Your Ref reference EN020022

**Aquind Interconnector Nationally
Significant Infrastructure Project Examination: Deadline 2**

Deadline 2 response from Winchester City Council

Plate 2 - Plots 3-12 and 3-13 as shown on Land Plan submitted at Deadline 1

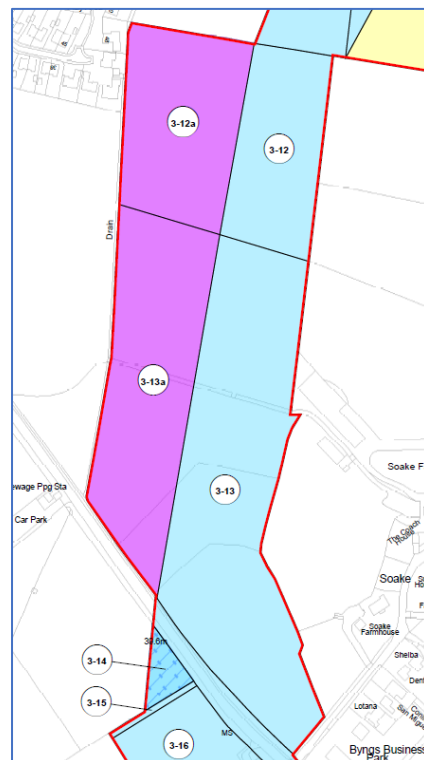
The Council notes in 3.1.1.6 the adjustment to the land required for New Connection Work Rights at Soake Farm. However, the Council strongly objects to the retention of access rights as a haul route across this land as shown on plates 1 & 2. A section of this haul route would cross part of the SINC designation.
